Ref: Planning Application R/215/15/HH
at - 28 Park Drive, Rustington.

We write to object to the planning application above on the following grounds:

Proposed West Elevation (rear)

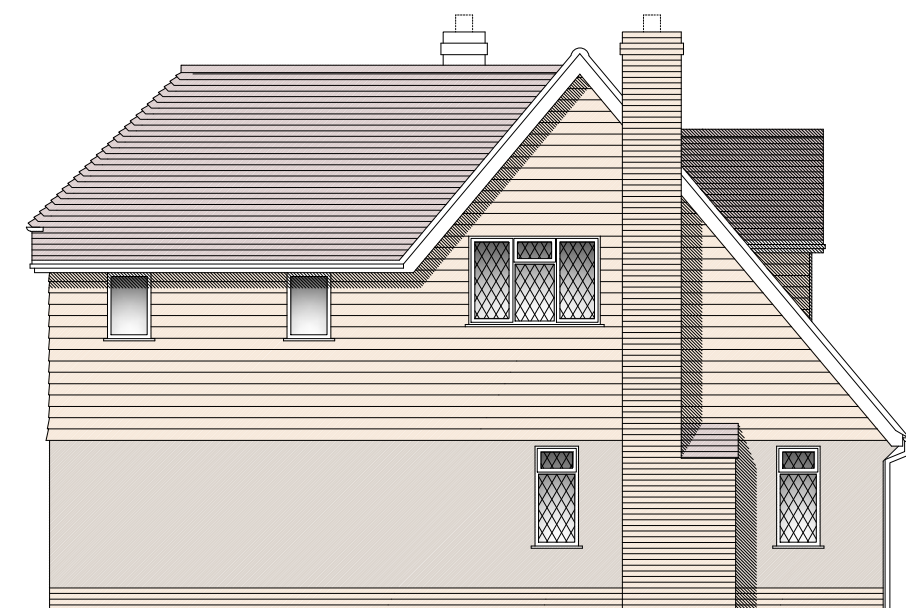
The proposals include a large window (some 2.4m x 1.0m) in the west elevation which would directly overlook our bungalow and garden and would adversely affect our privacy and the enjoyment of our own property.

In the event that our objection is overruled, however, we should ask the Council to attach a Condition to the grant of planning permission, namely, to reduce the size of the window in the west elevation or to relocate the proposed window to the south elevation, in exchange for the smaller twin windows in the south elevation.

This would have the advantage of reducing the visual intrusion into our property and would not increase the intrusion over the neighbouring (commercial) property to the south whose north elevation is largely wall and whose employees are unlikely to be affected.
